Planning Application Ref: AW/403/21/T

Location: The Water Tower, 16 Craigweil Manor, Aldwick PO21 4DJ

Description of works: Crown reduction of 1no. sycamore tree (T1) by approx. 1.5m - 2m back to previous pruning points

Location and Description of works. 16 Craigweil Manor, Aldwick, PO21 4DJ

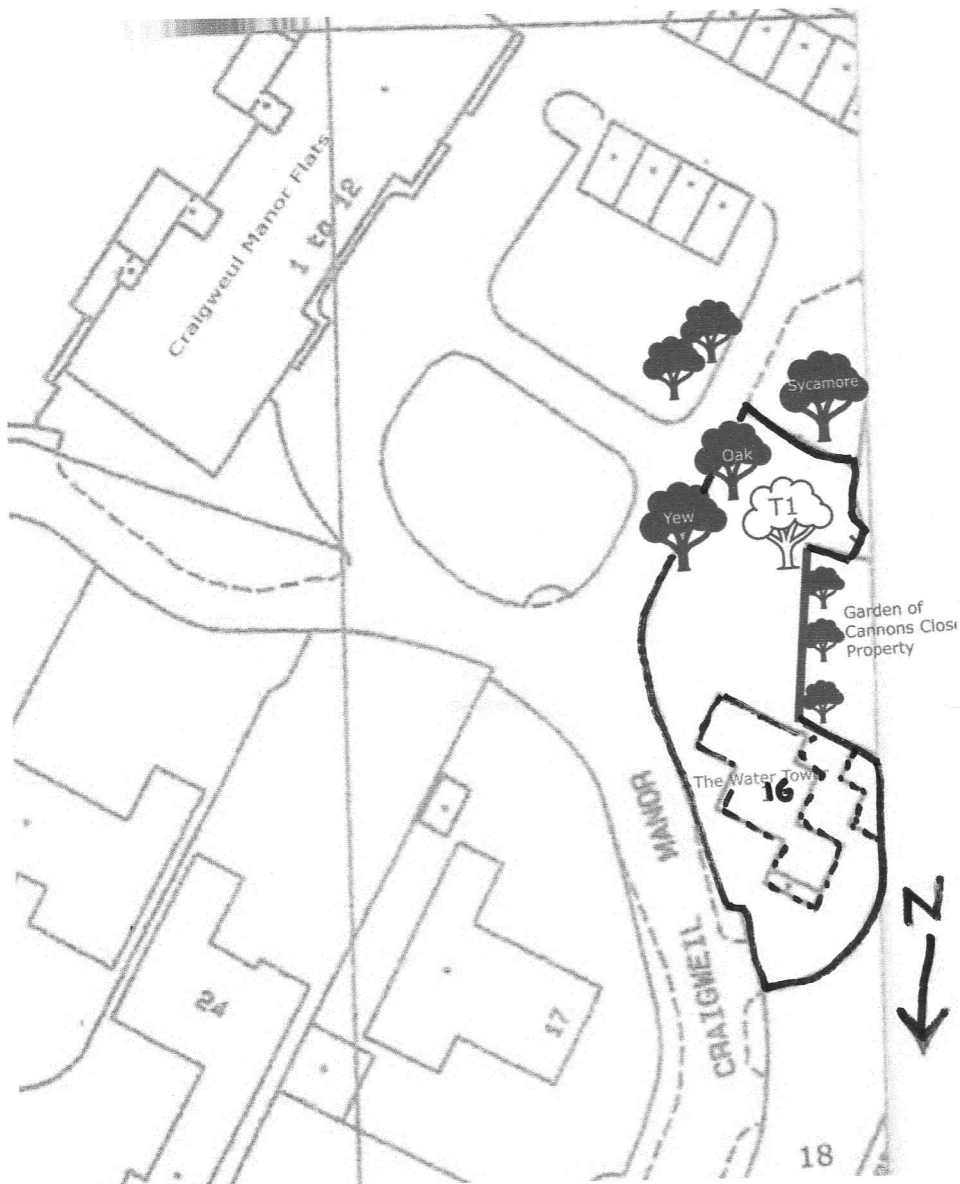
- The proposal to reduce the tree's overall height and spread with a view to restricting growth is justified and consistent with previous works approved by the Local Planning Authority.
- If the work is undertaken to a good standard and at the right time; then it is unlikely to have an adverse effect on the tree's long-term vitality and visual amenity.

- I recommend **CONSENT** for this application, subject to the following condition:

Part a) Where whole branches are to be removed and final cuts made close to the trunk or branch union they are to be made as shown in Figure 2 of BS3998:2010

Part b) Where branches are to be shortened back the final cuts are to be made at the correct angle shown in BS3998:2010 and adjacent to a live bud or lateral.

Part c) The removal of crown material which has developed since the last operation must be done sympathetically and with respect to established 'knuckles' so as not to extend beyond the point of origin.
